From: RICHARD TAFT [REDACTED]
Sent: 31 October 2012 16:24
To: Katherine Rawlins
Cc: debben818@aol.com
Subject: Little Thatch FP 153 12

Project: Proposed alterations; Little Thatch, Downview Road, Felpham PO22 8HH	
Drawing: Elevations as proposed	
For: Mr. R. Taft	
Drawn: PKS	Date: July 2012
Scales: 1:100	No: 960/01/05
To scale when printed on A3

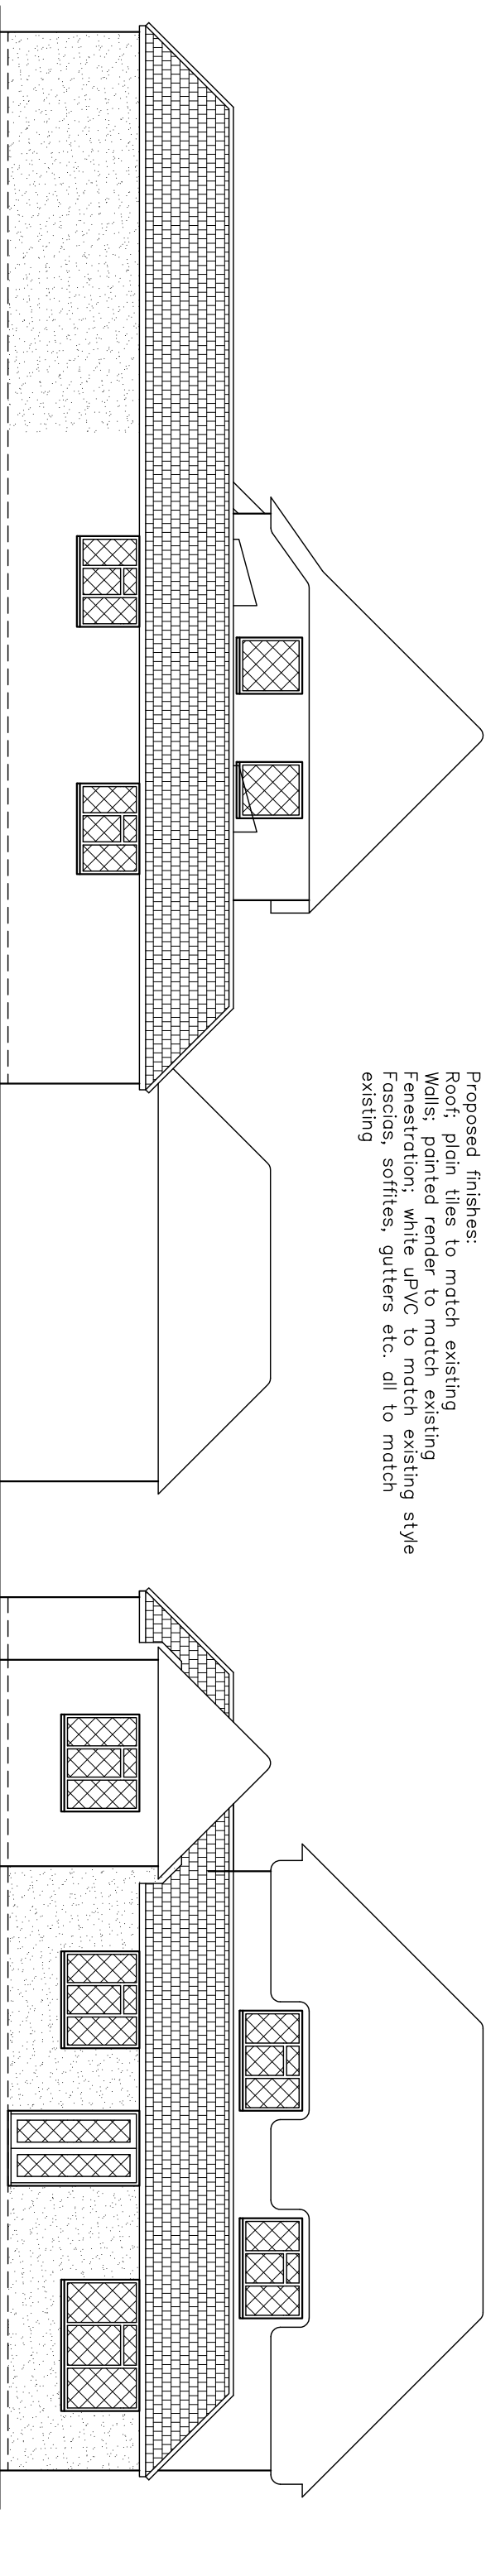
With Ref to our telephone conversation to day re above project, I would confirm the clients would prefer an additional glazed window to be added to North wall of shower room(as per drawing deposited), situated in existing annex.
